Immingham Green Energy Terminal

10.1 Proposed Change Notification Report

March 2024

Document Reference: TR030008/EXAM/10.1

Site Boundary & Works Plans Changes between DCO Application (September 2023) & Change Application (March 2024) Key Plan

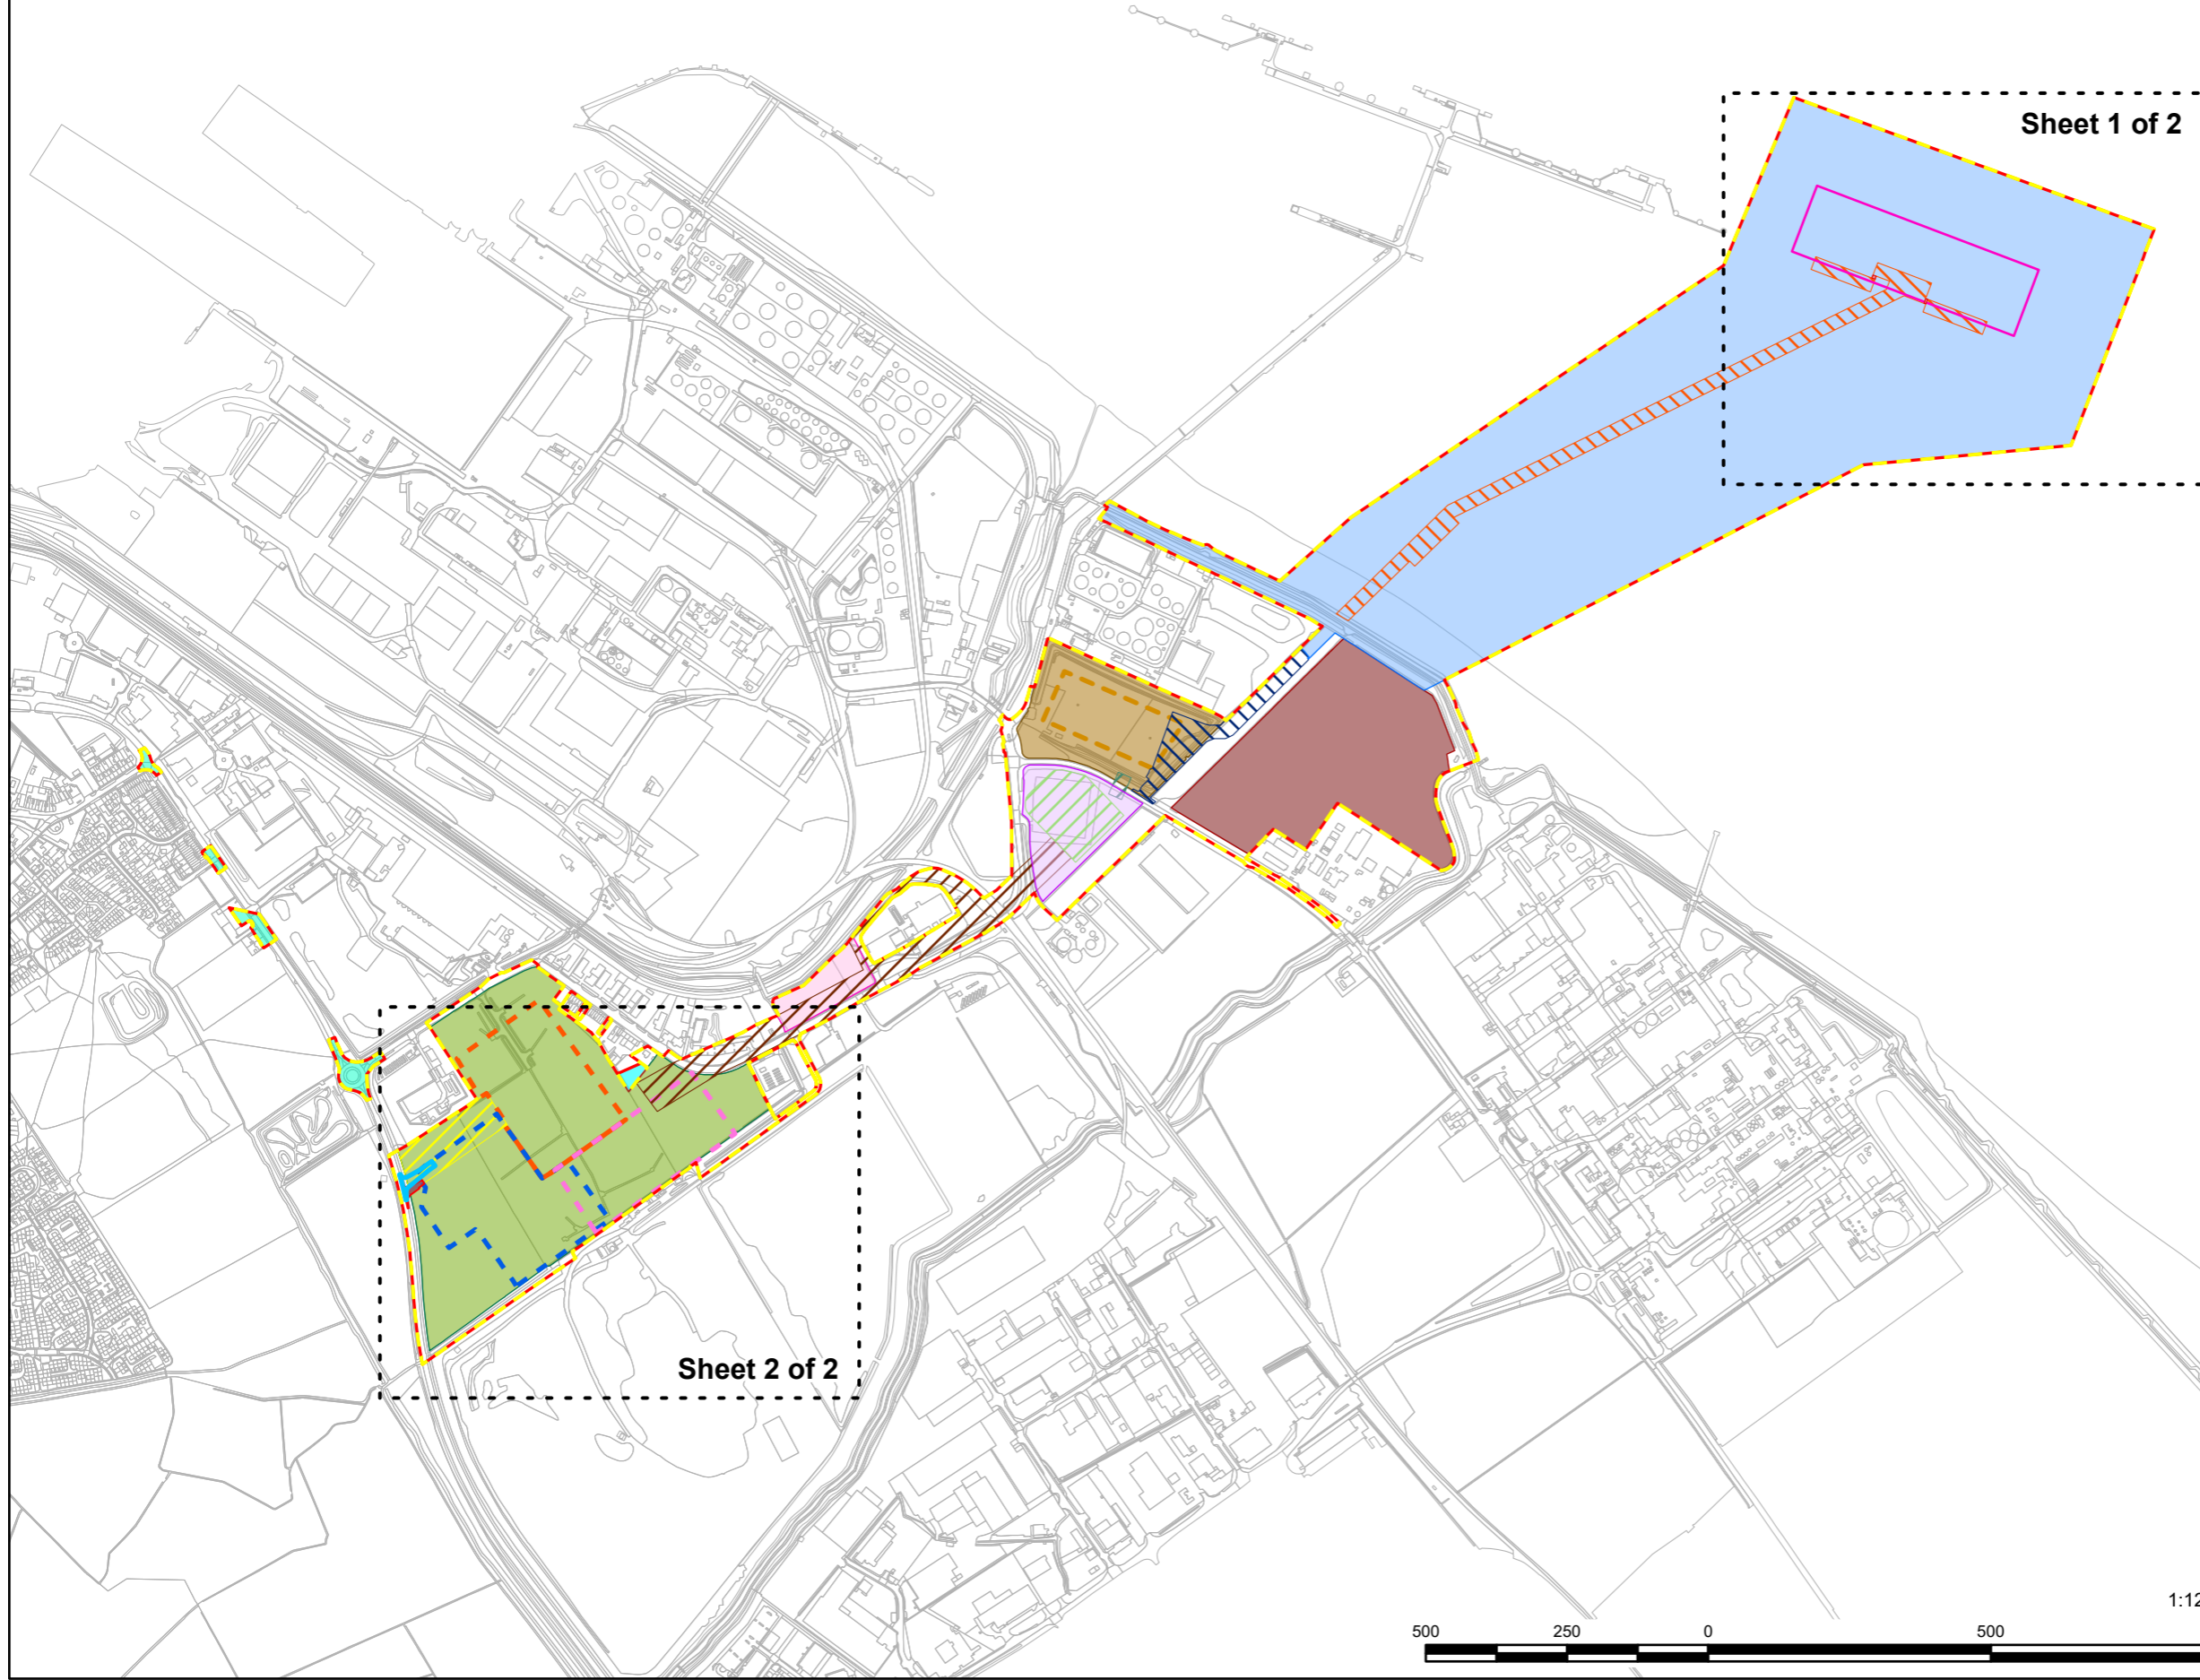
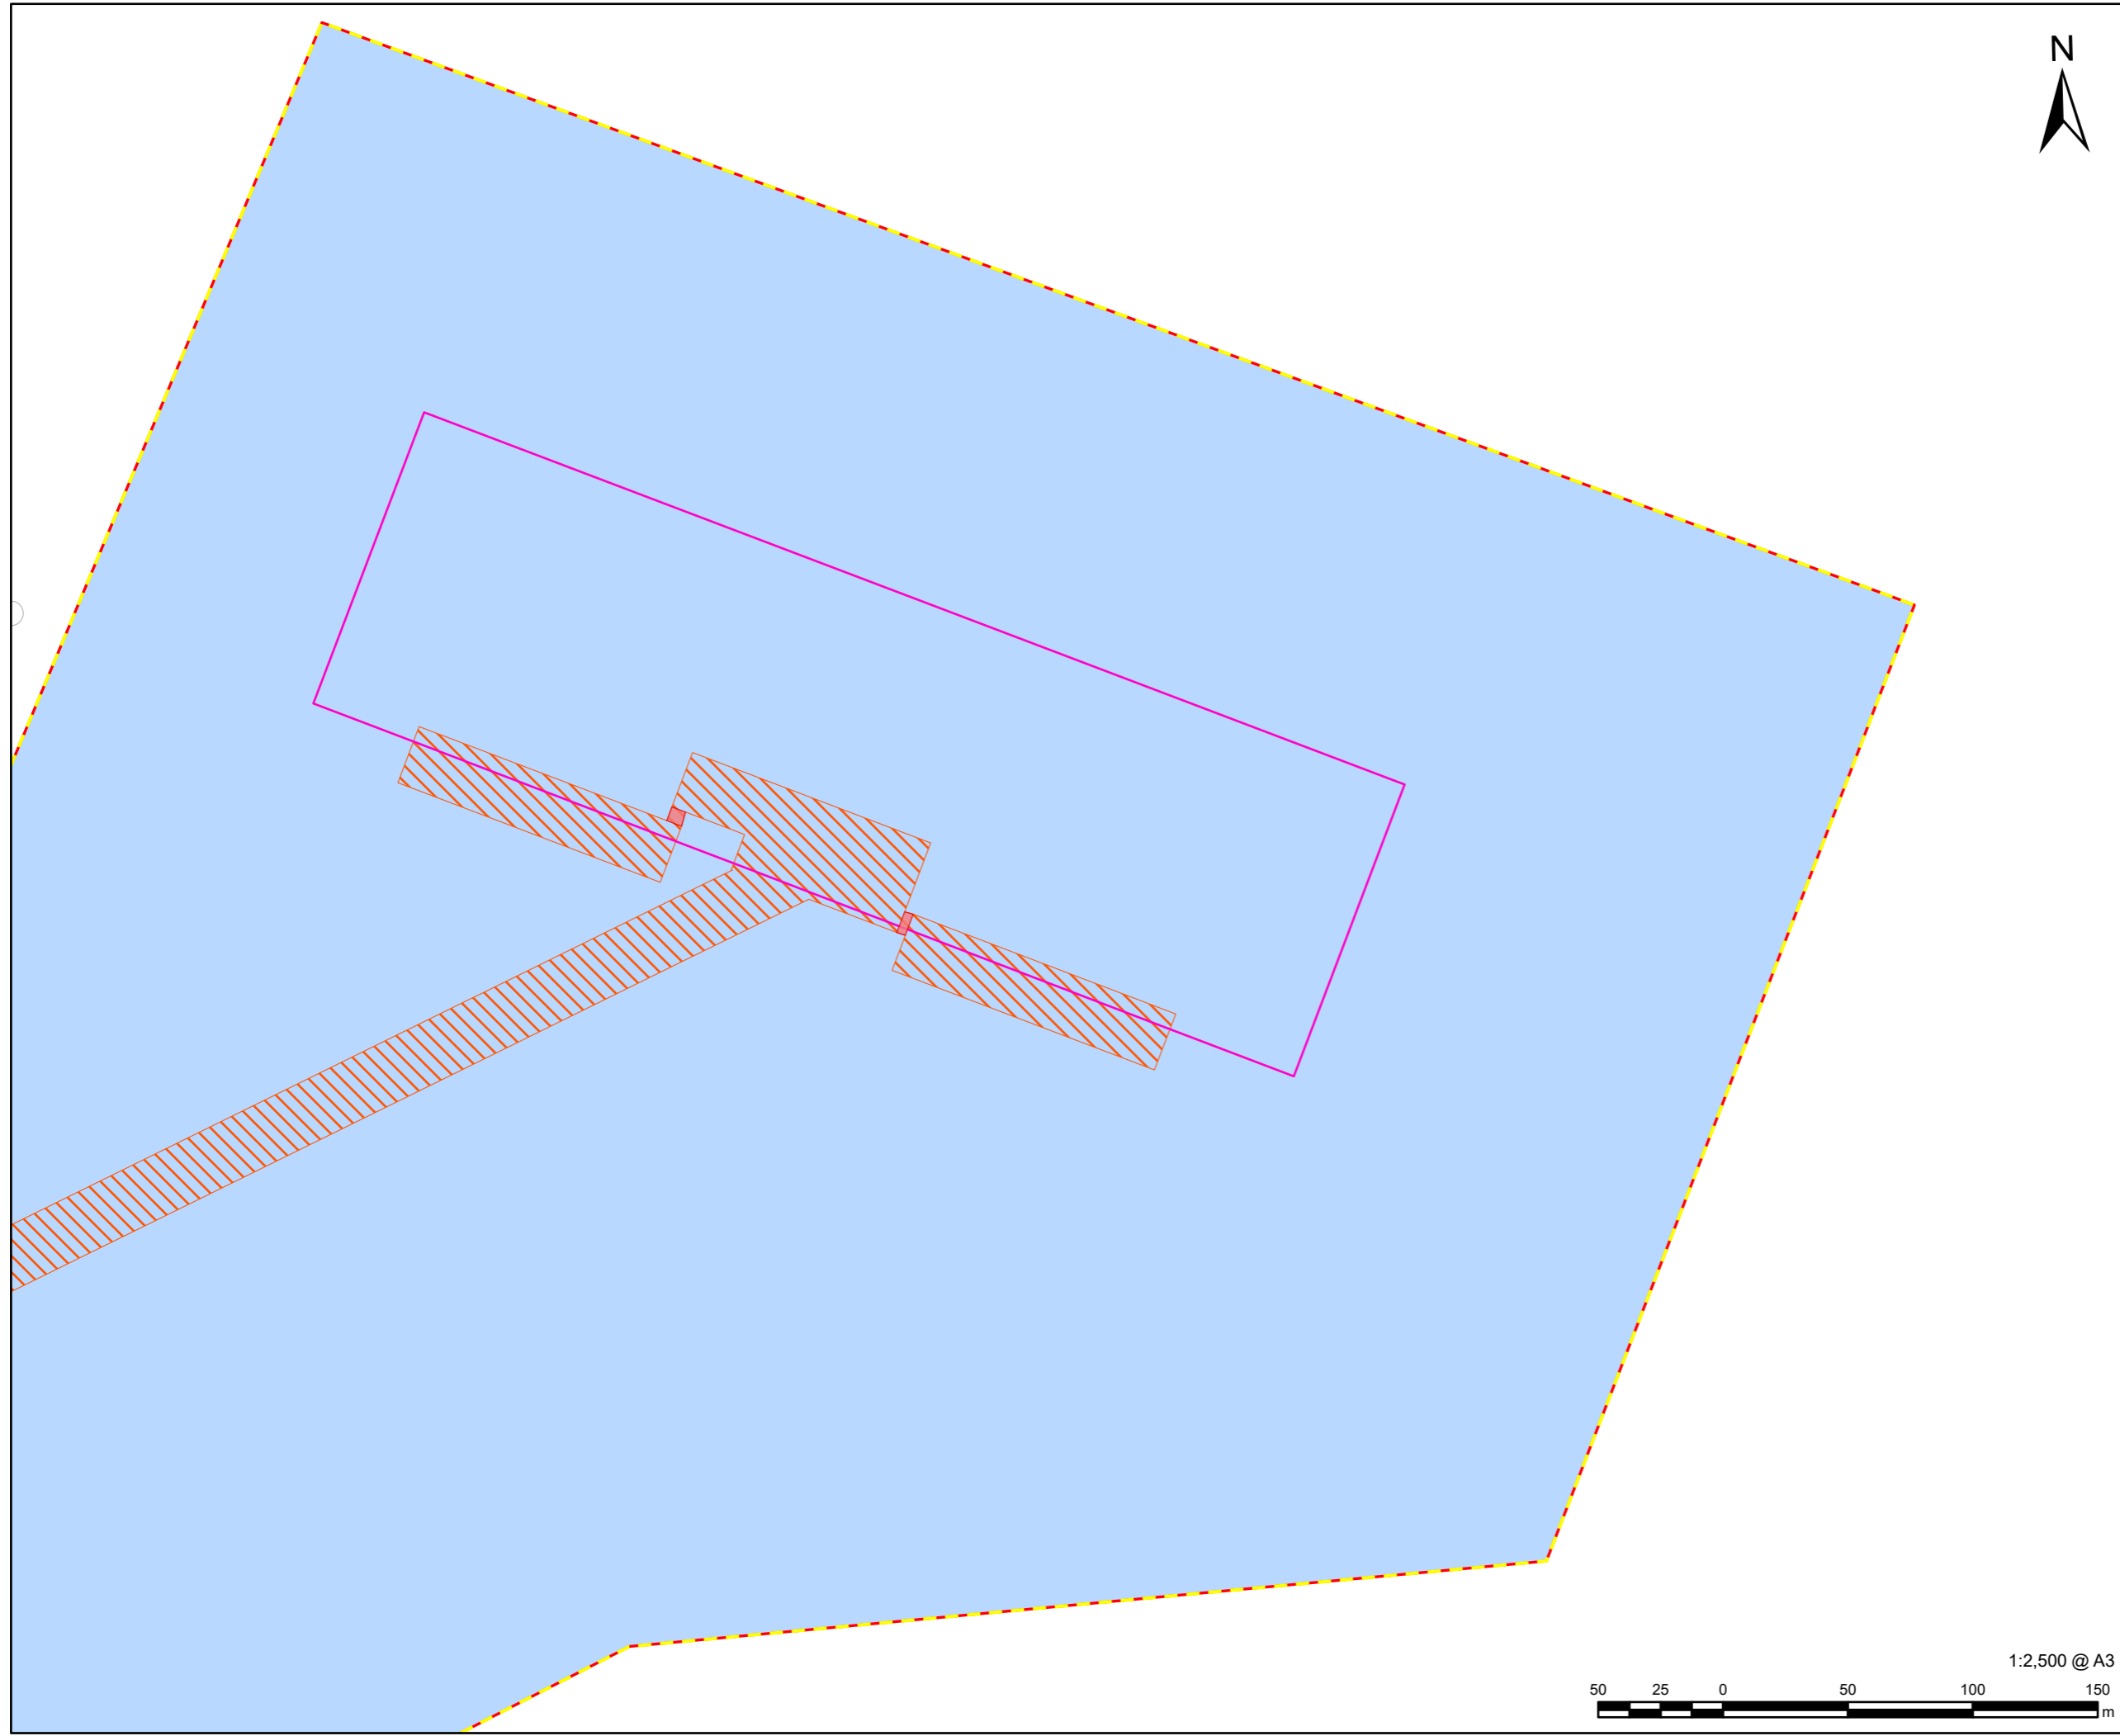
- 2.4.1 Proposed Change 3 comprises minor changes to the northern access from the A1173 to Work No. 7 (marked "AB" on the Street Works and Accesses Plan [APP-016] and referred to as "Access AB" below) and amendment of the red line boundary (Order Limits) at the eastern edge of Work No. 7 to include additional land for temporary construction purposes.

- 2.4.3 Proposed Change 3 requires the extension of the red line boundary to include a small area of additional land to the east of Work No. 7. The inclusion of this land is for the purposes of construction, and therefore powers of temporary possession are sought in respect of this land, rather than powers of compulsory acquisition. As a result, the CA Regulations are not triggered by this Proposed Change 3. The outline Construction Traffic Management Plan will be updated to reflect this change.

- 2.4.4 Proposed Change 3 also includes minor changes to Access AB. As a result of the slight shift of the likely layout of the hydrogen production facility, Access AB needs to be adjusted by approximately 10-15 metres to the north west.

2.5.1 Proposed Change 4 consists of the addition of visual detail to Work No. 1a in the Works Plans **[AS-002]** to include the walkways linking the jetty head to the mooring dolphins as shown in Work No. 1a. These walkways are already described at Paragraph 1(a)(i) of Schedule 1 (Authorised Project) and at Paragraph 3(2)(a)(ii) of Schedule 3 (Deemed Marine Licence) of the dDCO **[REP1-016]**.

2.5.2 The visual addition of the walkways in the Works Plans **[AS-002]** is shown indicatively in Figure 5 below and on Sheet 1 of 2 in Appendix 3.
